From: Mark Warwick [REDACTED]
Sent: 20 August 2019 14:23
To: Tom Wallace [REDACTED]
Cc: Lauren Wiltshire [REDACTED]; M Weaver [REDACTED]; Reece Cahill [REDACTED]; Tom Moody [REDACTED]; Simon Davis [REDACTED]; Paul Cann [REDACTED]
Subject: Land at Stanhorn Grove, Felpham - FP/171/18/PL

As part of the sustainable drainage formation at Stanhorn Grove Felpham we have to clear the ditch behind plot number 10-14 to gain the required invert levels from the hydrobreak to the ditch. To do these works we need to use a track machine. My problem being that this would involve tracking a machine into the TPO fencing around T-12 and T-13. I have held a meeting Paul Cann on site to plan these works to schedule these works and we thought it would be prudent to inform you the works that are required. We intend to use a small excavator that won't interfere with the crown of the trees. Can you foresee a problem with this?

Drawing:
Soft Landscaping Concept

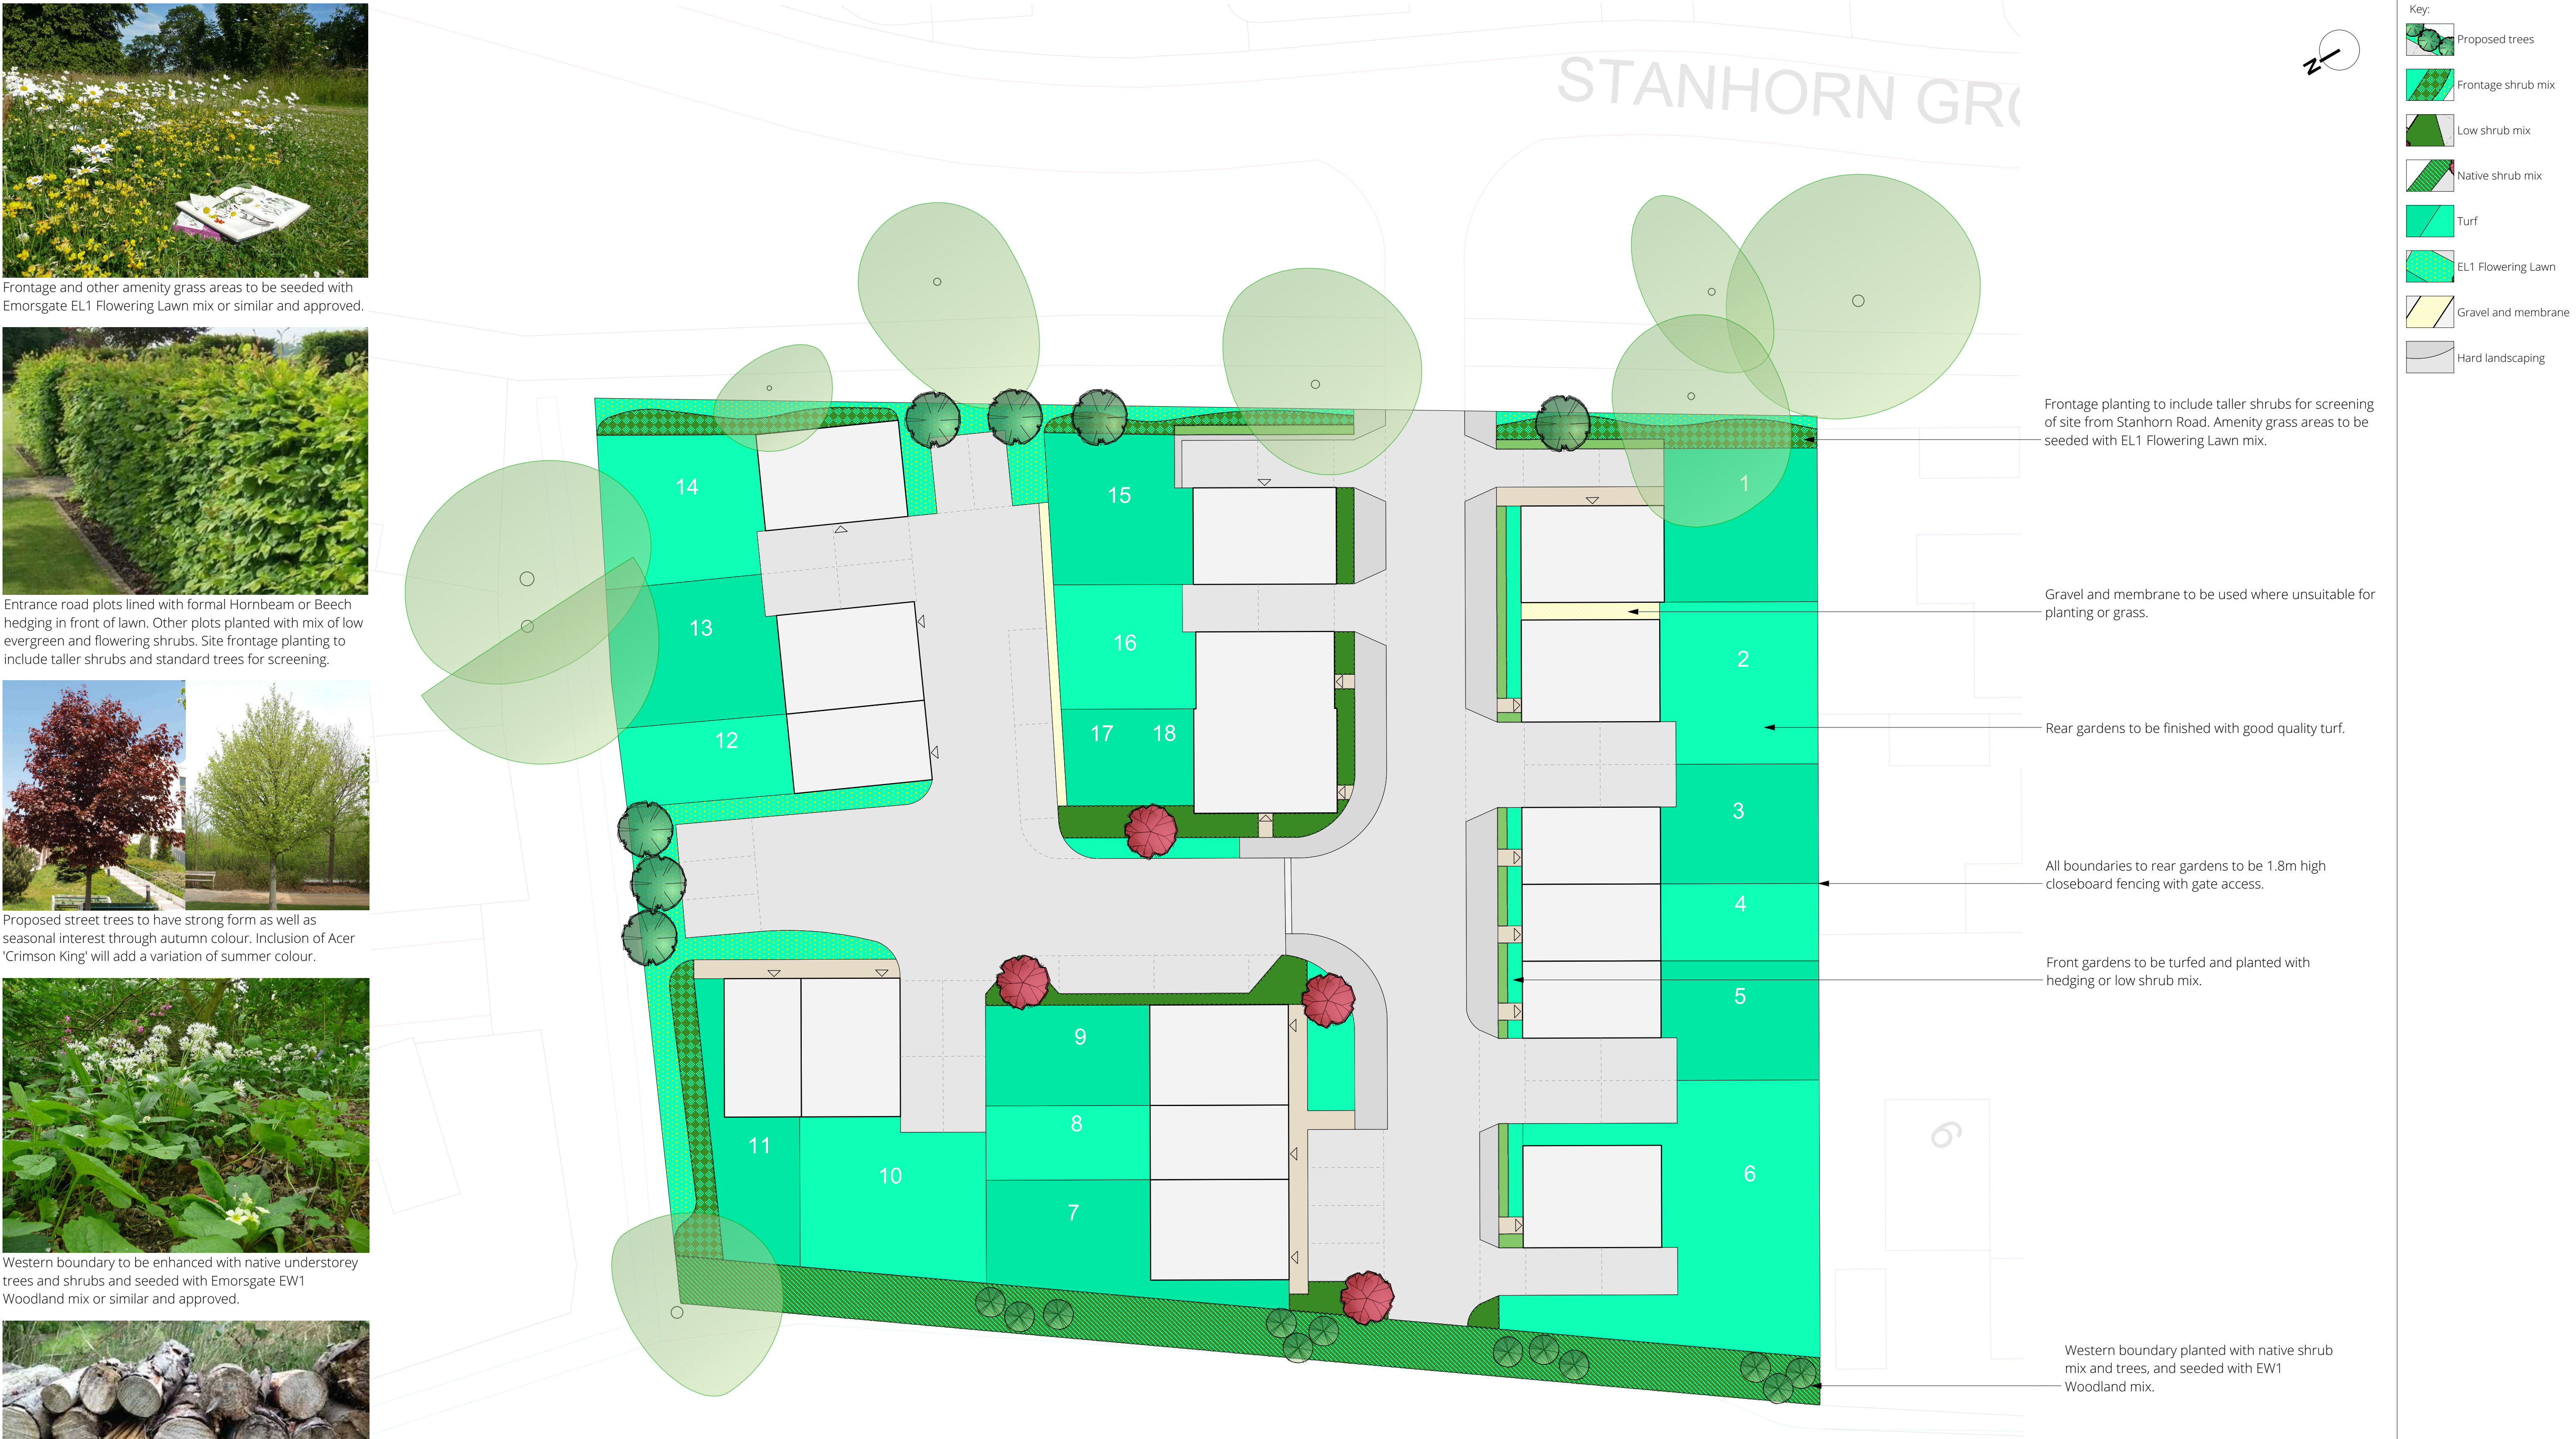
You are proposing to use heavy plant within the root protection area (RPA) of retained tree(s). Some of those trees (T12 & T13 oak, T14 ash) appear to be under 3rd party ownership and all enjoy statutory protection (TPO). It is my view that the roots of those trees (already compromised by built development to the north) will have tracked beneath the ditch and up into your site and so the nominal RPA should be respected.

In the absence of any; ground protection measures, detailed specification for the proposed work, approved method statement, site supervision by project arboriculturist – I have serious concerns for the ongoing health and vitality of the tree(s).

On a separate but related matter, it would be prudent for your arboriculturist to undertake a condition survey of those trees. As mentioned during my last visit to this site, one of the aforementioned oak trees is displaying a large bracket fungus which may have significant implications for its structural integrity. This should be brought to the attention of your neighbour if it is not considered to be growing from land under your ownership.

I suggest you instruct your project arboriculturist to consider the above and provide you with a detailed set of recommendations and advice on how best to proceed. I would also expect them to provide us (Simon Davis and myself) with a copy of their report/recommendations and subsequent evidence (an auditable trail) of their on-site supervision of those works, so as to clearly demonstrate the trees have been adequately respected and protected throughout your operations.
